# ENG-SP20003-R2-PDR-redlines.pdf Markup Summary

SP-20-003

GRANCH PHASE 2 May 2020

# STERLING RANCH PHASE 2 PROPOSED DRAINAGE MAP

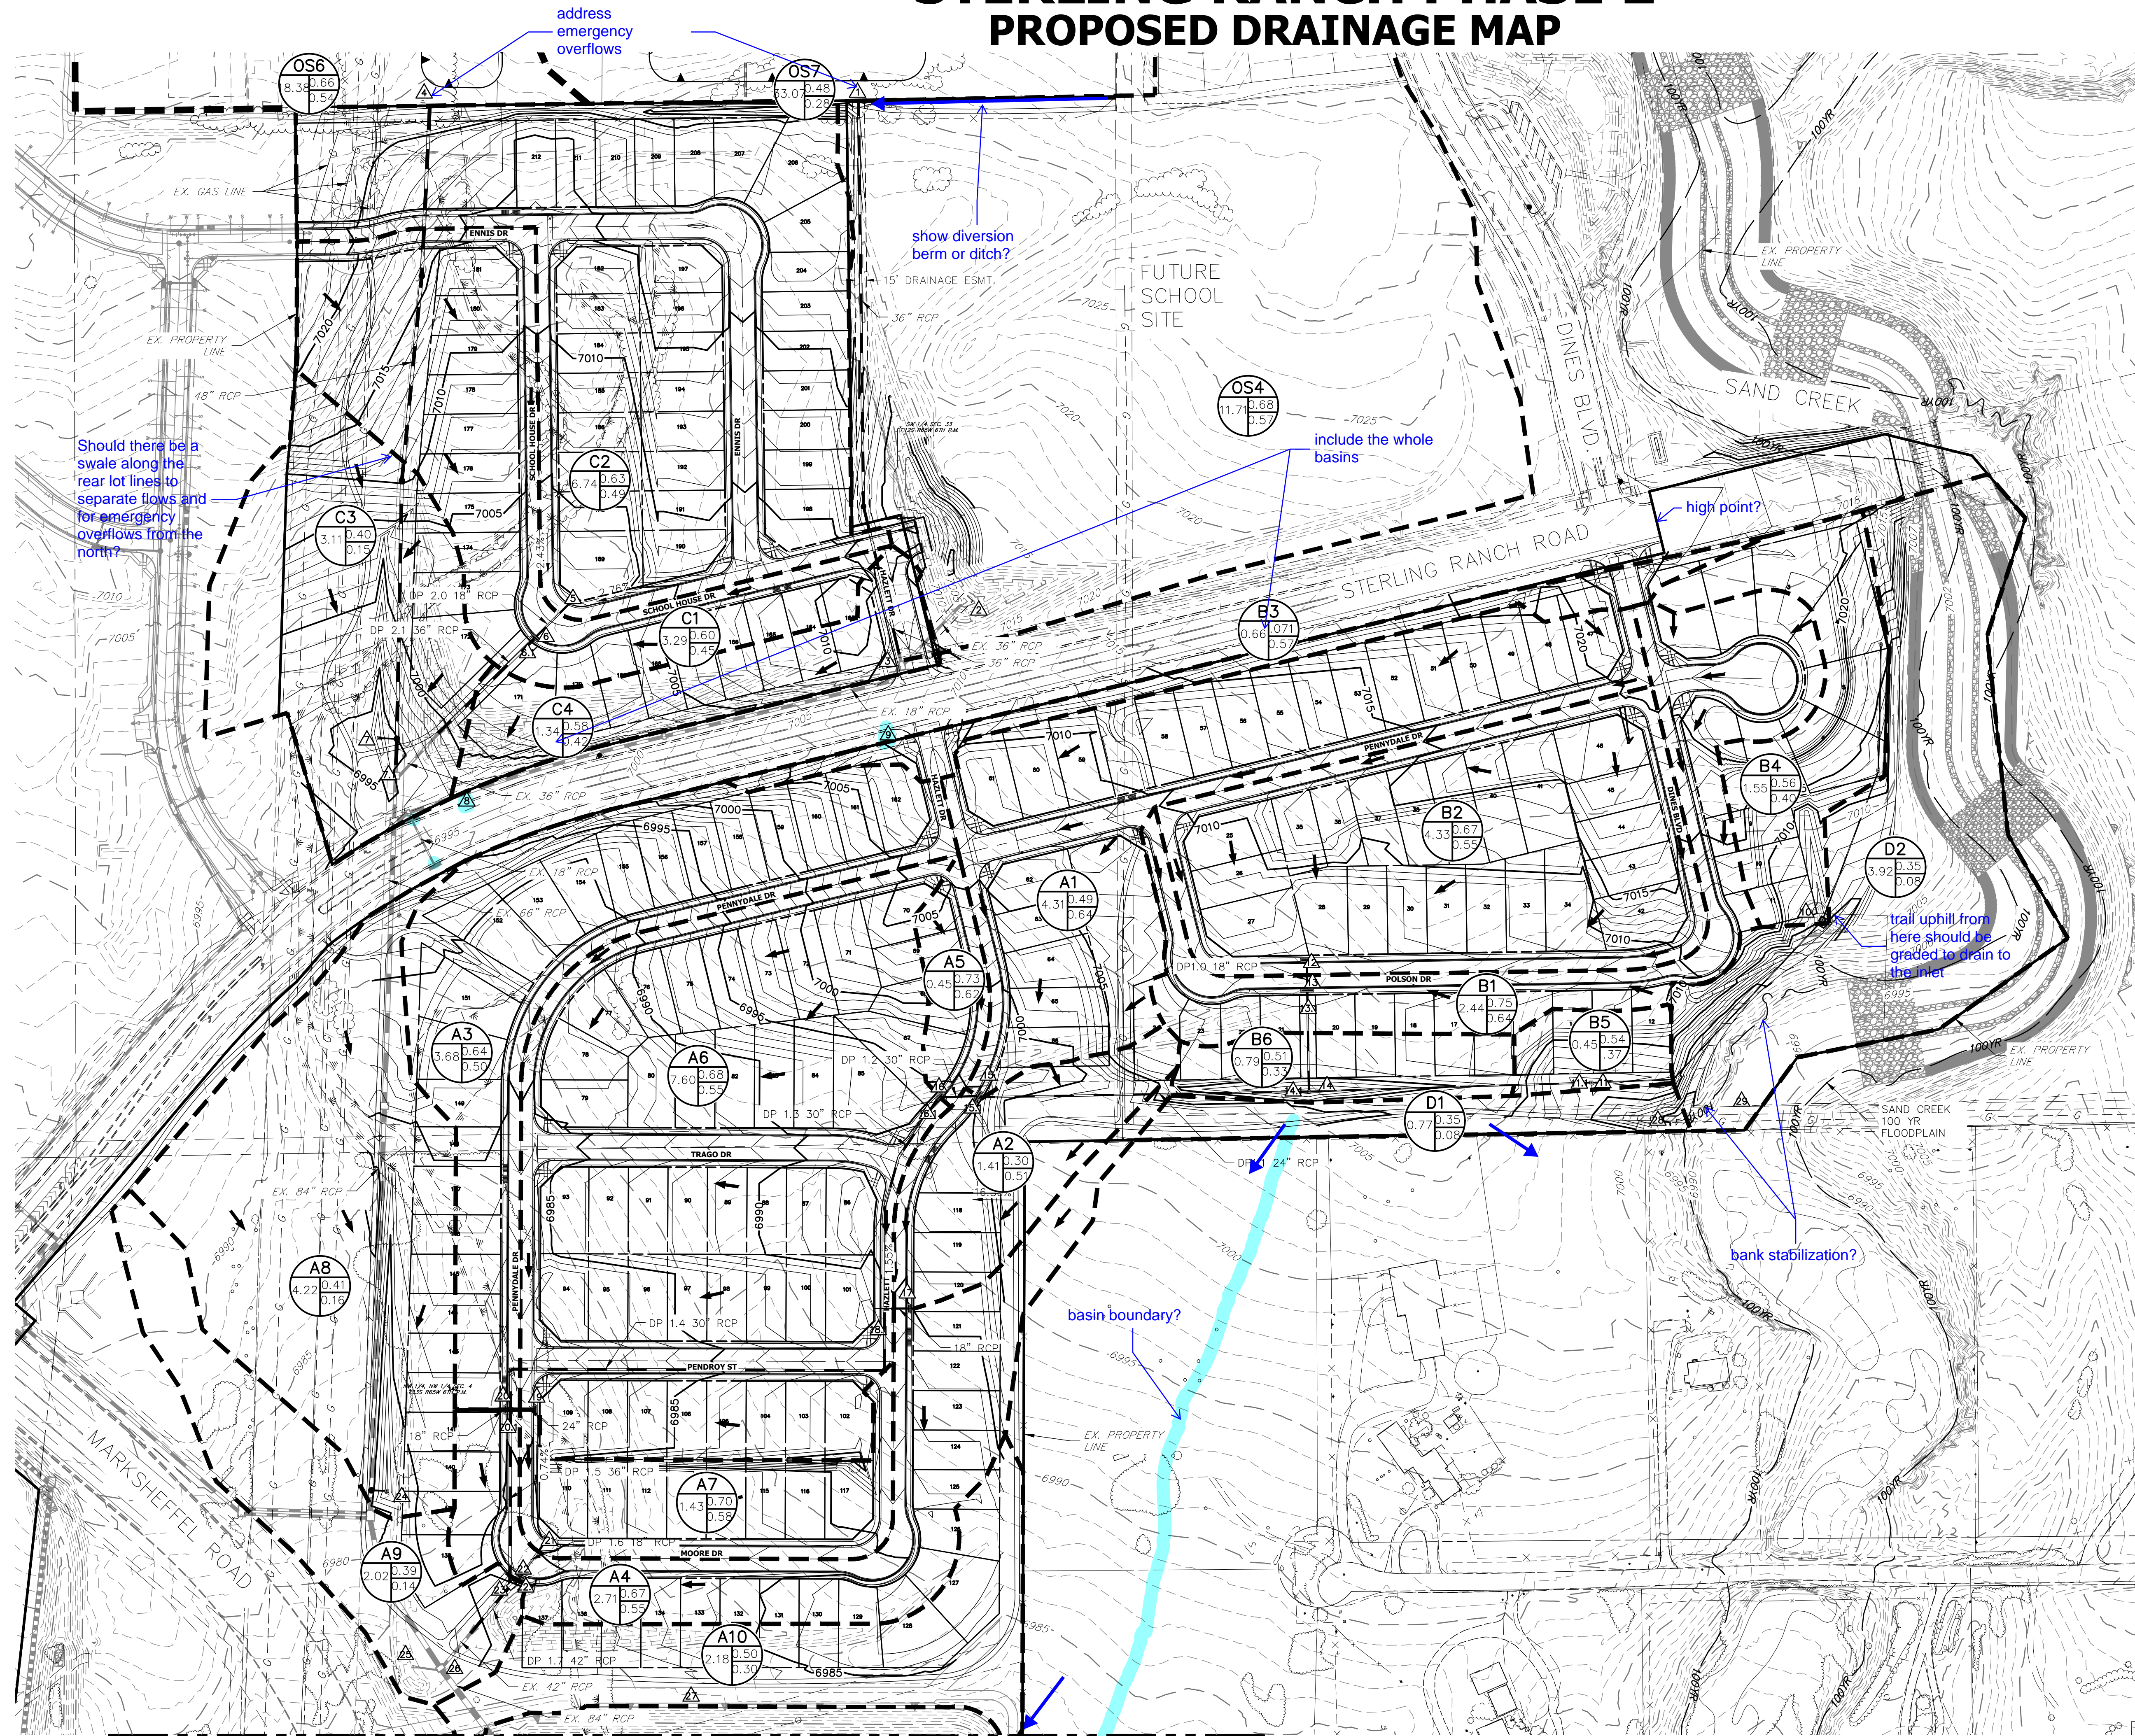
Show current grades or label grading as assumed to exist following projects to the west. Are Marksheffel Road plans south of Sterling Ranch Road proposed?

Also provide the Existing Drainage Plan from SF20015 showing a larger area (with comments addressed) down to existing confluence

Show the existing upstream facilities, access roads and culverts

STERLING RANCH PHASE 2  
PROPOSED DRAINAGE MAP  
JOB NO. 25188.00  
09/25/20  
SHEET 2 OF 2

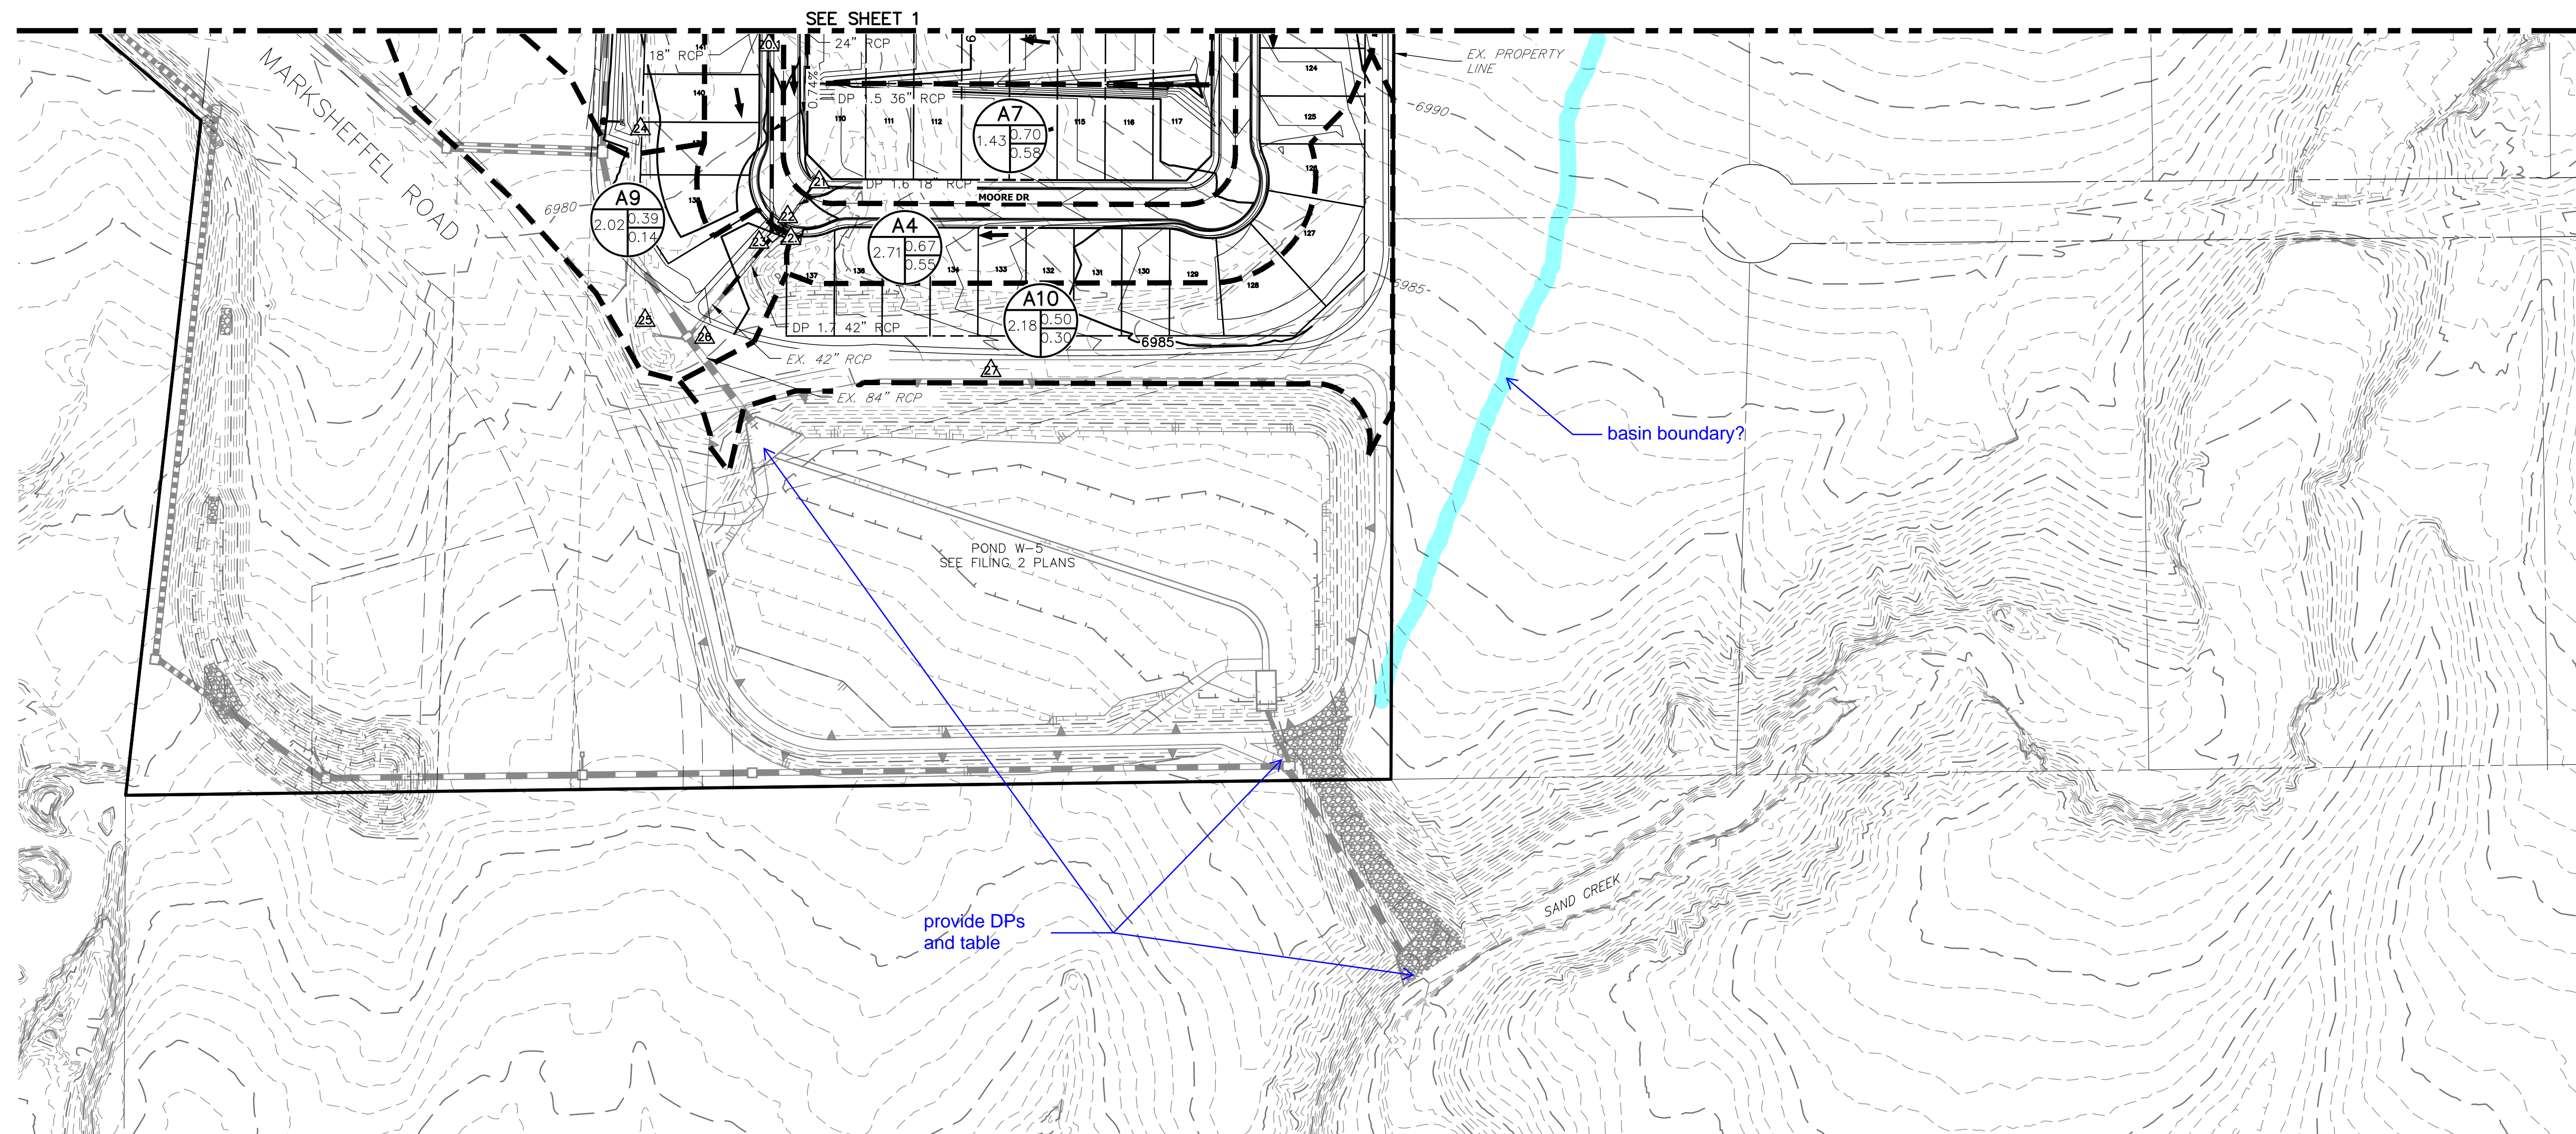
label pipes and easments

This area does not appear to comply with new MS4-related criteria. Provide additional WQCV BMPs as appropriate.

Show and label conceptual channel improvements

Provide a sheet showing Lift station tract, Marksheffel Road, Pond W5, all contributing flows to it and outfall improvements (including channel)

Provide the interim drainage plan proposed for early grading (to match GEC plan)

Are swales proposed along trails/property lines?

Show the existing upstream facilities and culverts. Show how flows will be intercepted. Provide design points and basins

label basin

label DP
